Historic England

Our ref: P01570137

15 January 2024

**THE INNOVATION QUARTER, BICESTER HERITAGE, BUCKINGHAM ROAD,
BICESTER, OXFORDSHIRE, OX26 5HA
Application No. 23/03438/REM**

BICESTER MOTION - INNOVATION QUARTER SITE PLAN

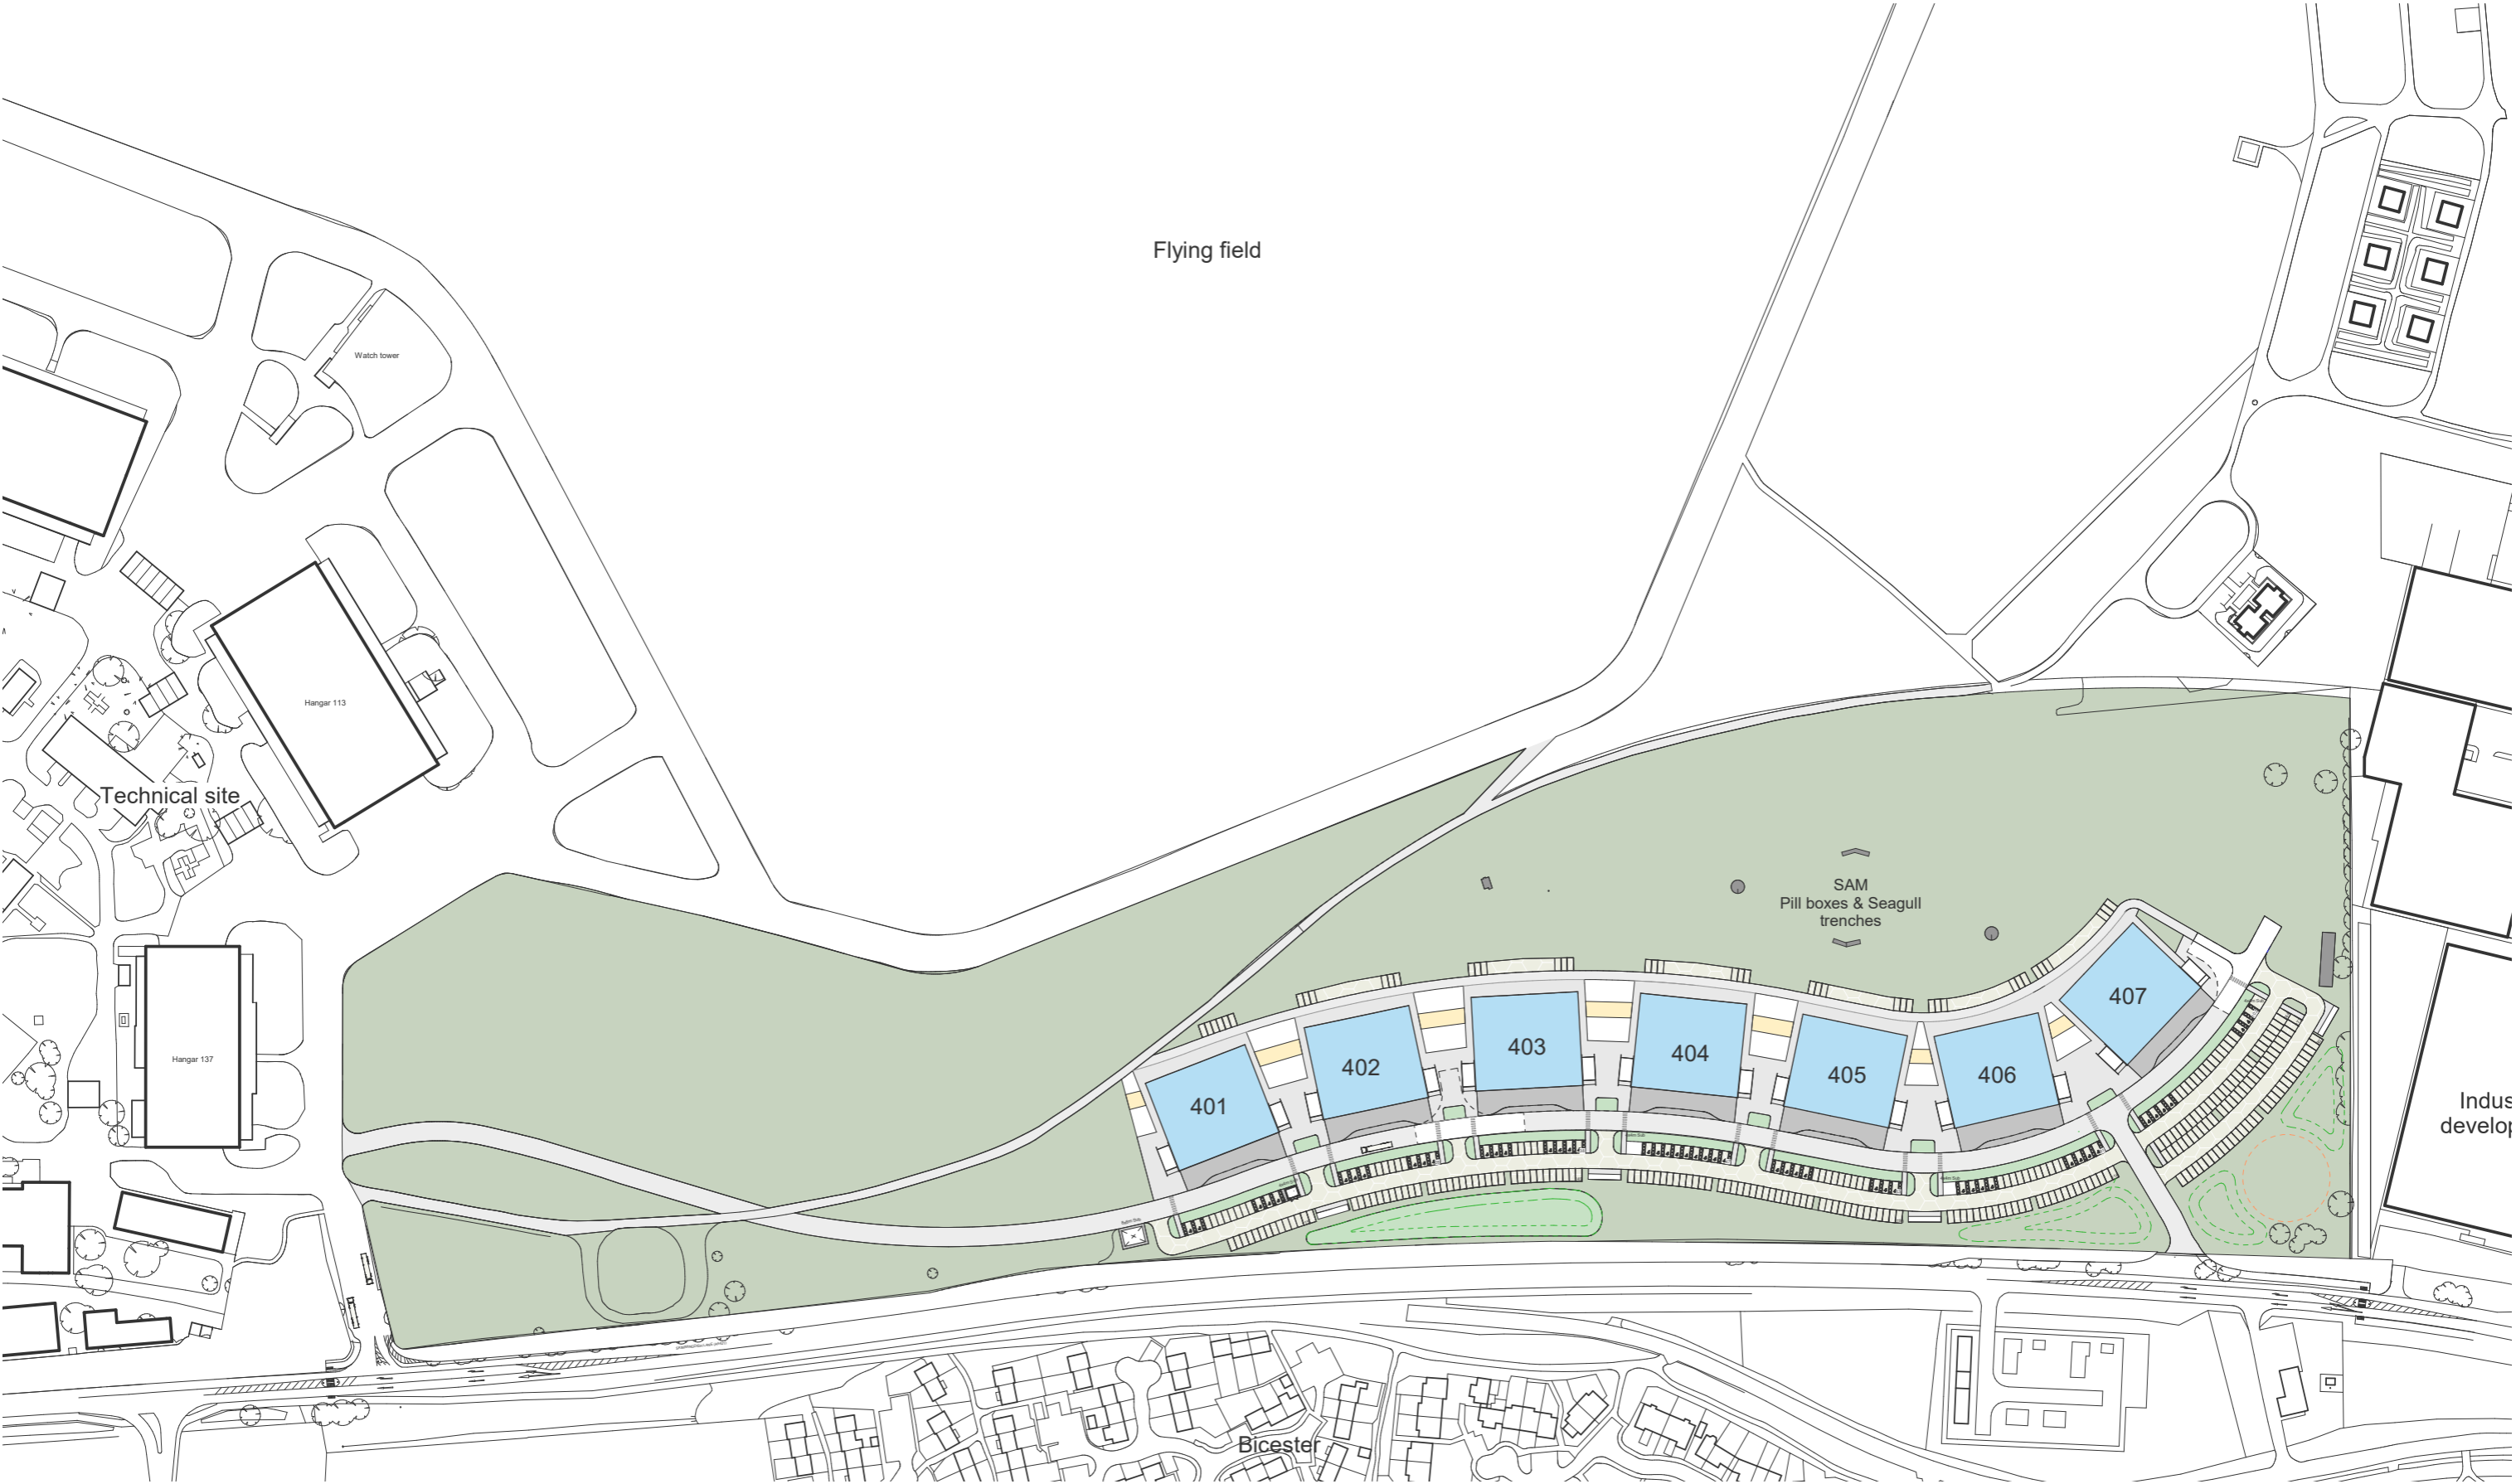
The current proposal places a 40m wide two-storey building squarely in the intended field of fire of the SW seagull trench, and this must therefore impact upon an understanding of its purpose. We remain of the view that this will cause harm to the scheduled monument.
